WEST SUSSEX COUNTY COUNCIL CONSULTATION

TO:	Arun District Council FAO: Juan Baeza
FROM:	Alison Meeus, Highways, WSCC
DATE:	22/06/2018
LOCATION:	5 Selbourne Place, Selbourne Road, Littlehampton
SUBJECT:	<u>LU-124-18-DOC</u> Discharge of condition 5, approval of details reserved by condition imposed under LU/298/17/PL relating to conditons 6 – Traffic and Parking Management details
DATE OF SITE VISIT:	n/a
RECOMMENDATION:	☐ Advice ☐ Objection ☐ Modification ☒ No Objection ☐ More Information ☐ Refusal
S106 CONTRIBUTION TOTAL:	£ See below for breakdown.

Discharge of Condition 6 – Traffic and Parking Management details

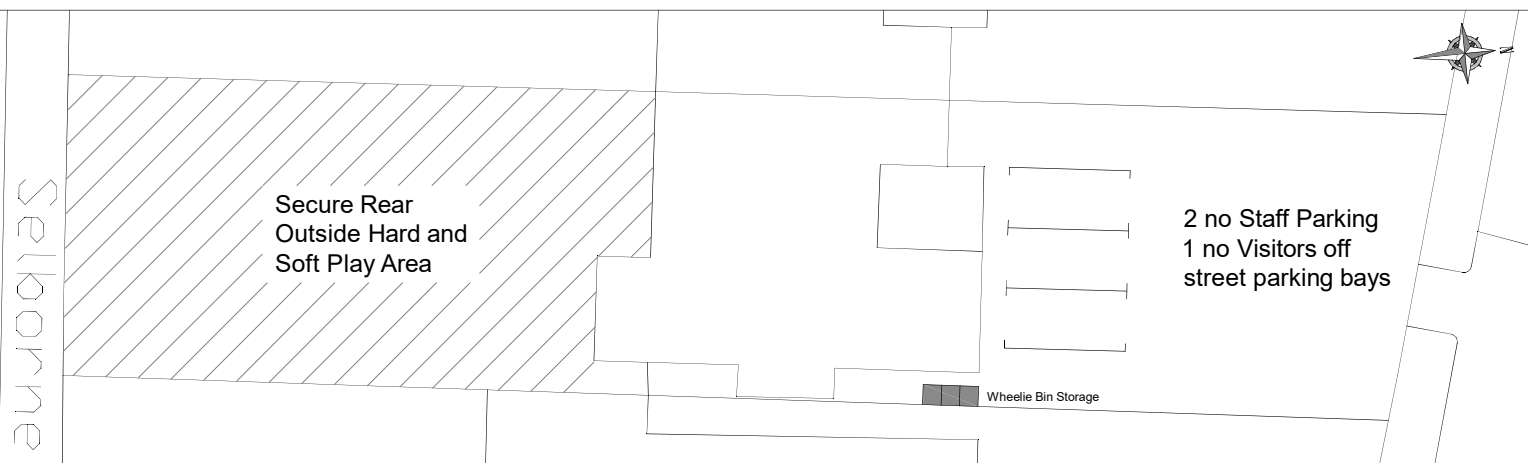
A plan showing a redesigned staff parking area is also required.

Plan PR/FP/03 is accepted showing two car parking spaces for staff and 1 visitor space.

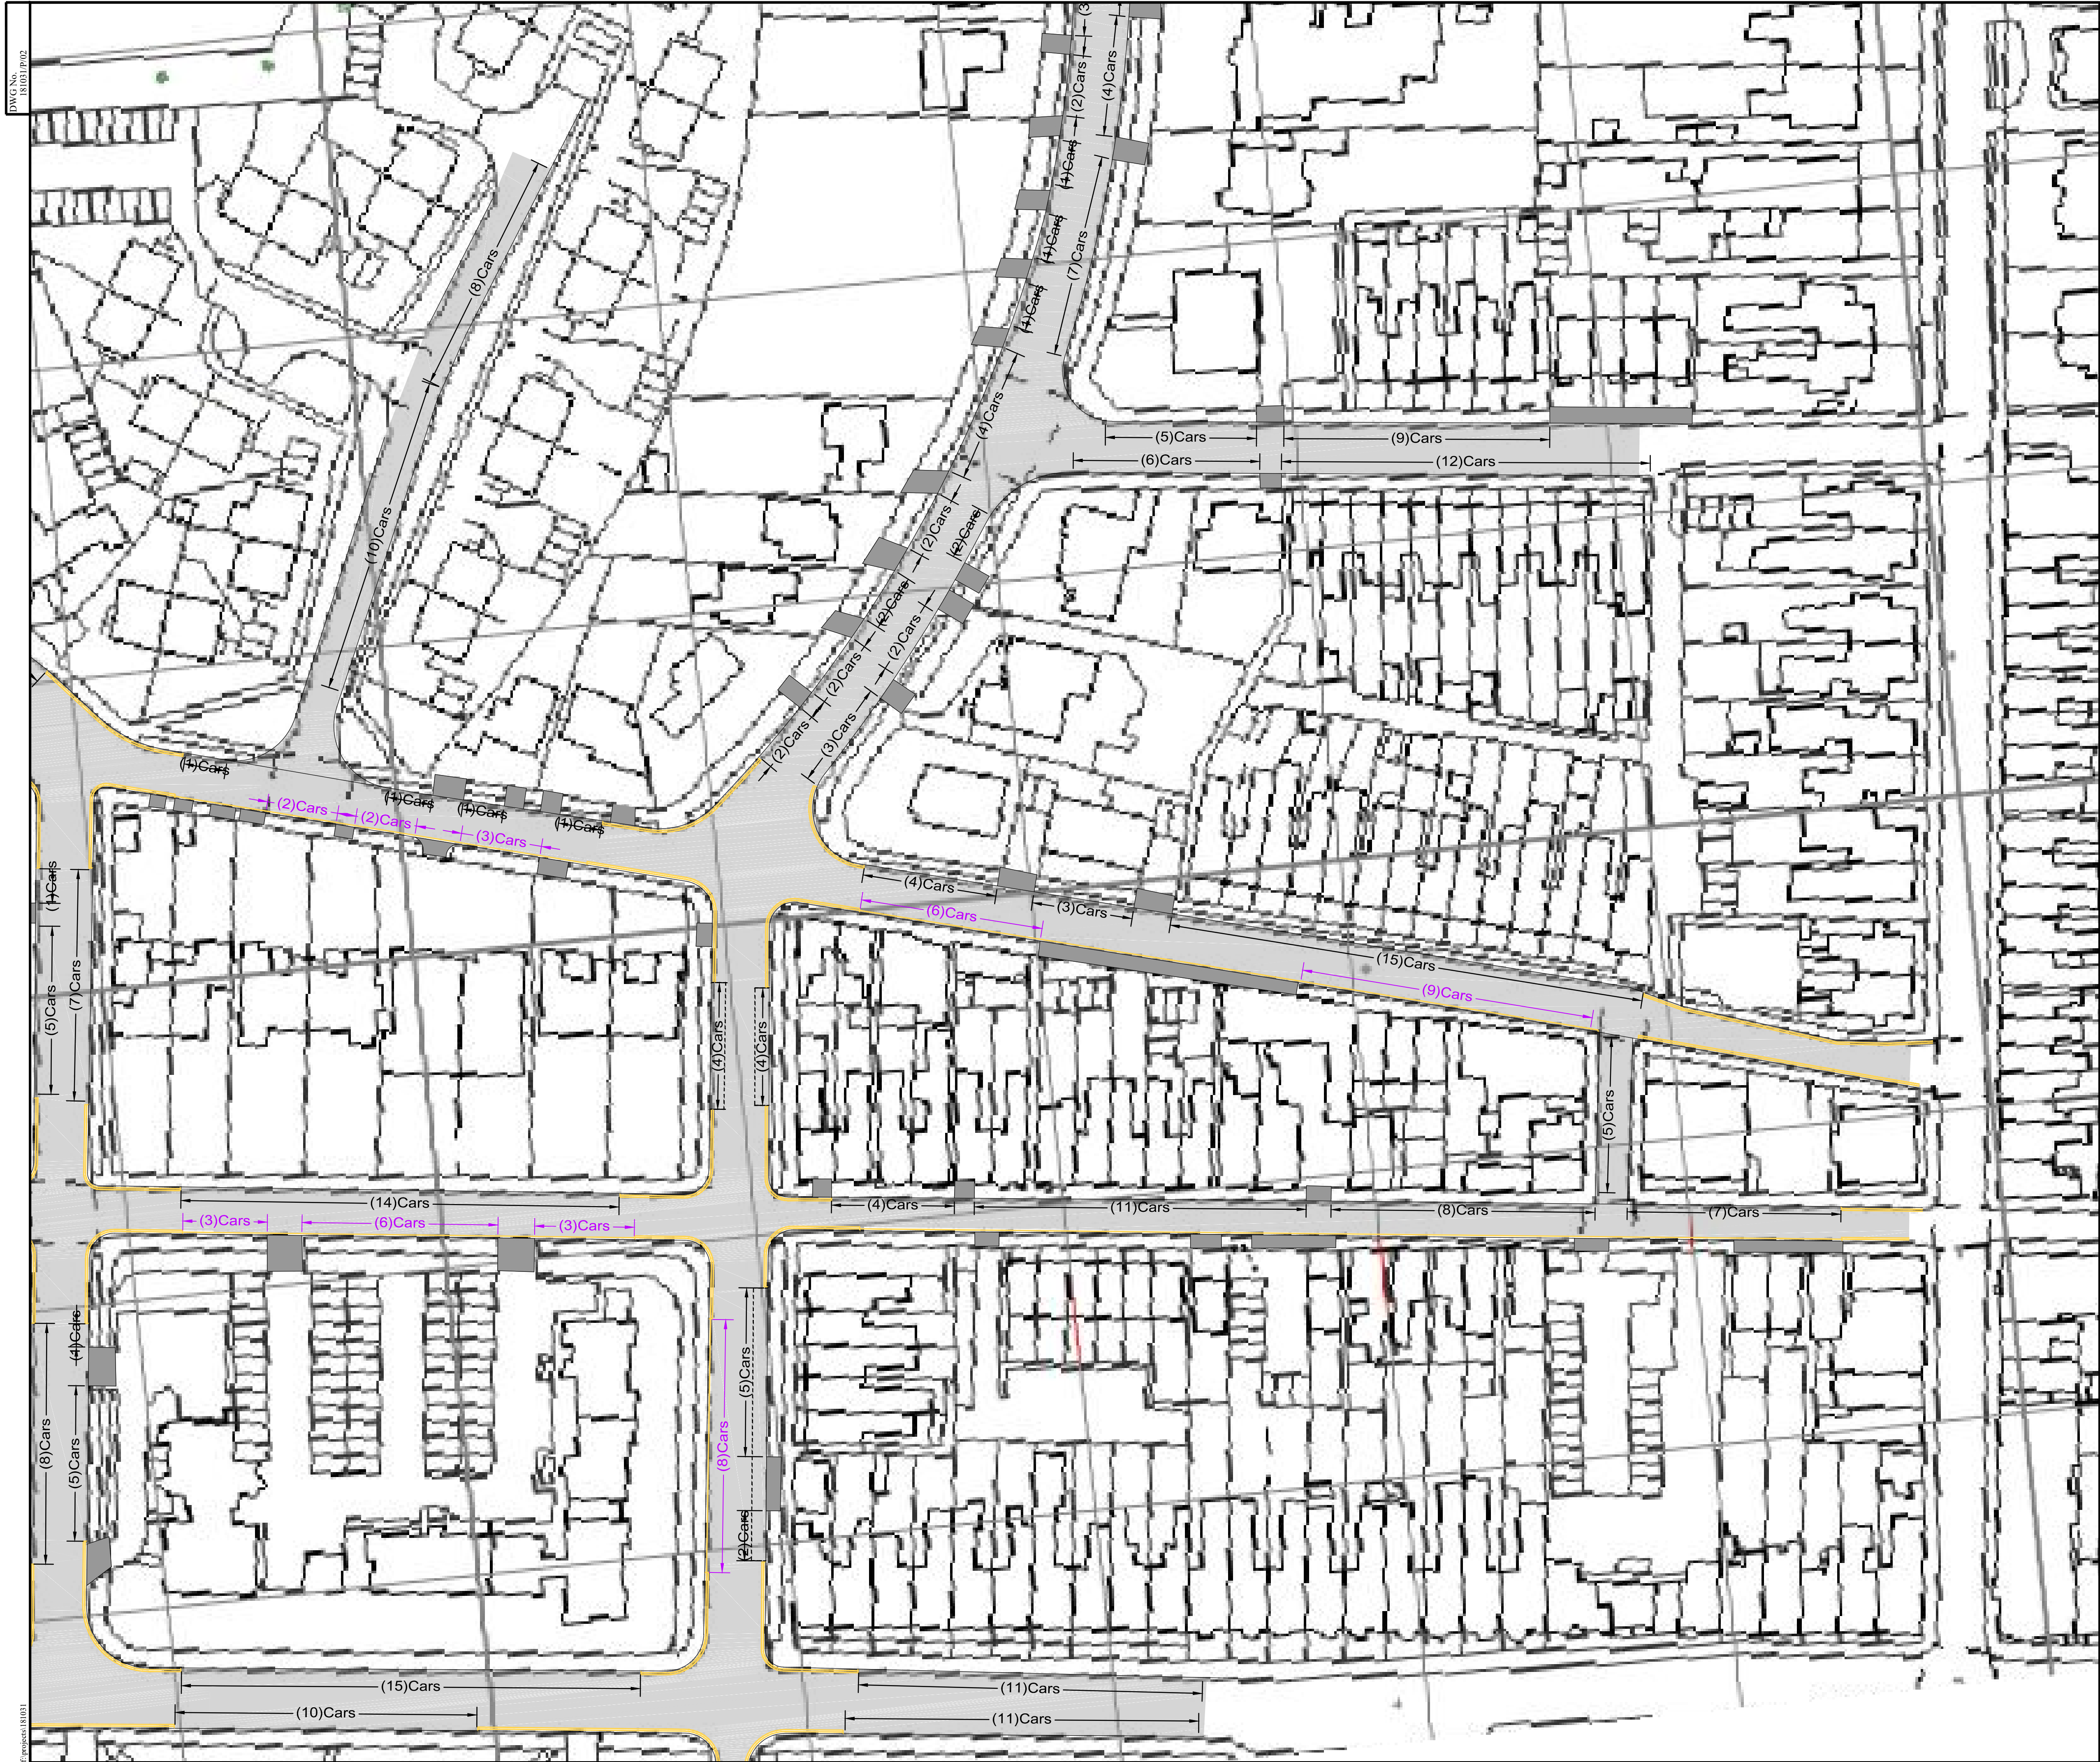
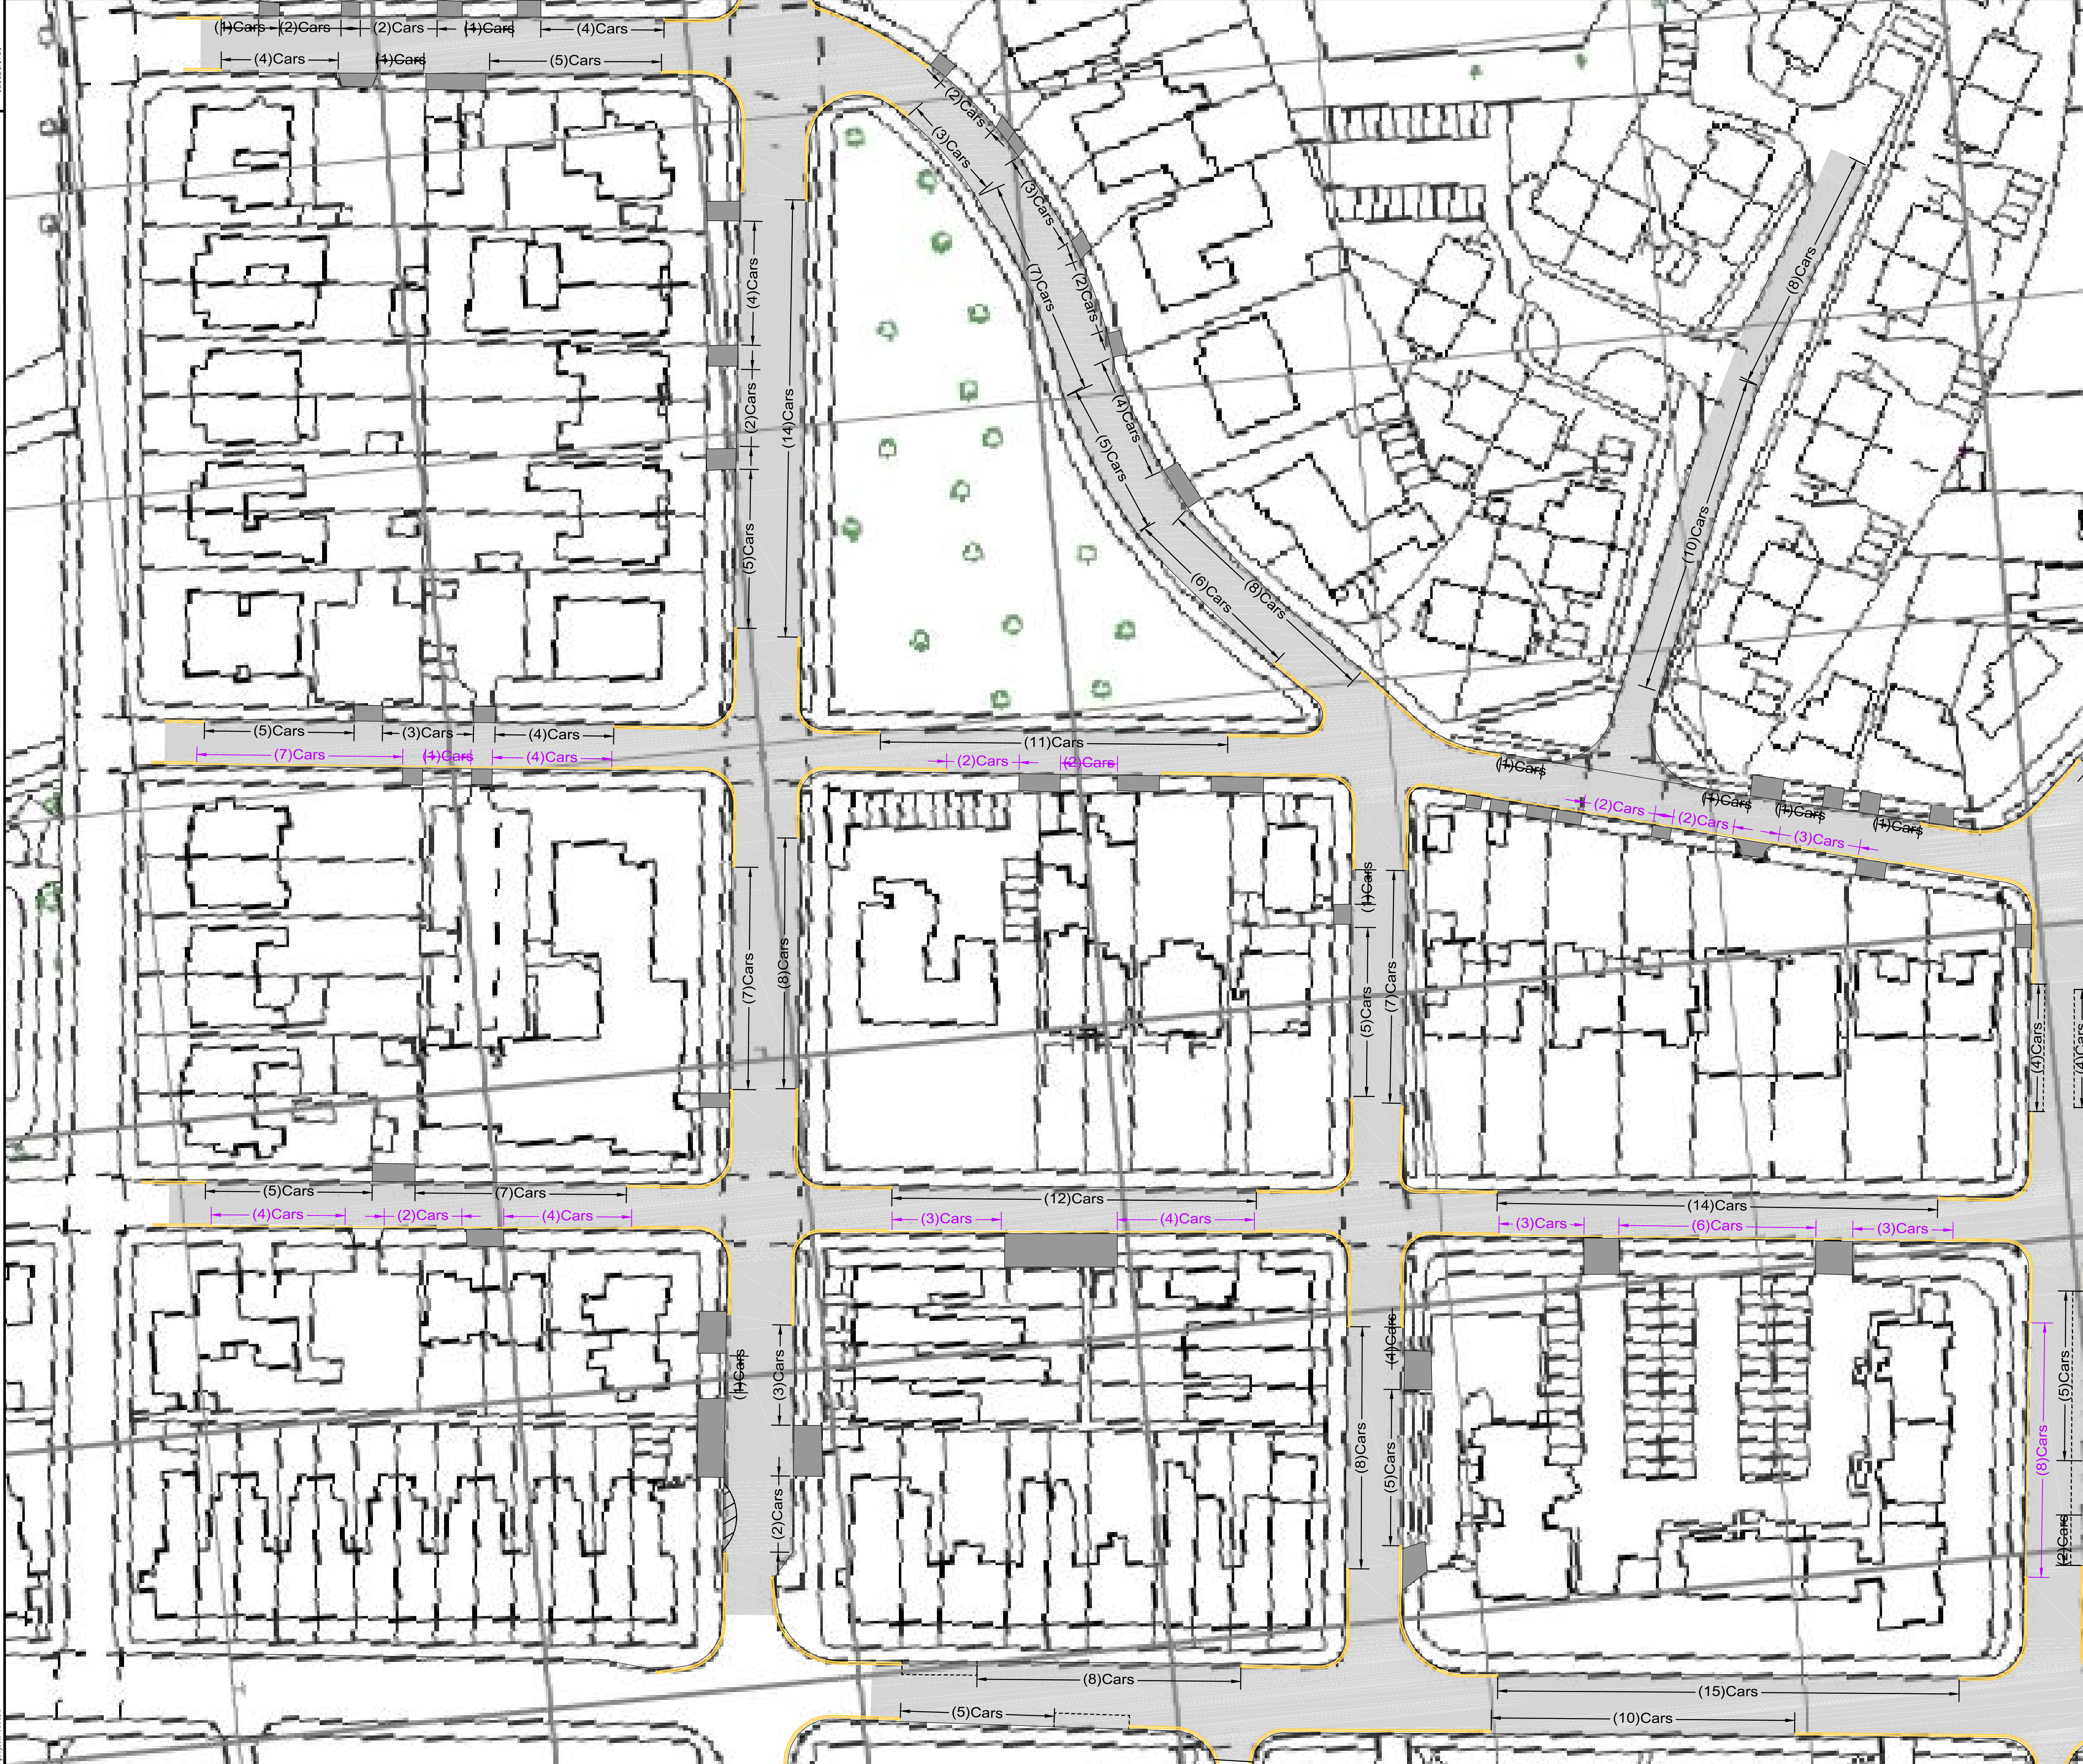
Further information on session times, plans to stagger start finish times.

Session times have not been provided however it can be assumed that peak drop off/pick up times for a nursery are 9am/12pm/3pm/6pm. Looking at these four time periods it is clear to see that the parking stress is not at its limit and as the nature of the traffic will be fleeting. SYL were identified in the survey and showed there is also the option to use these should 100% parking stress ever be experienced.

WSCC are satisfied there are enough spare spaces to cover demand from this proposed use.
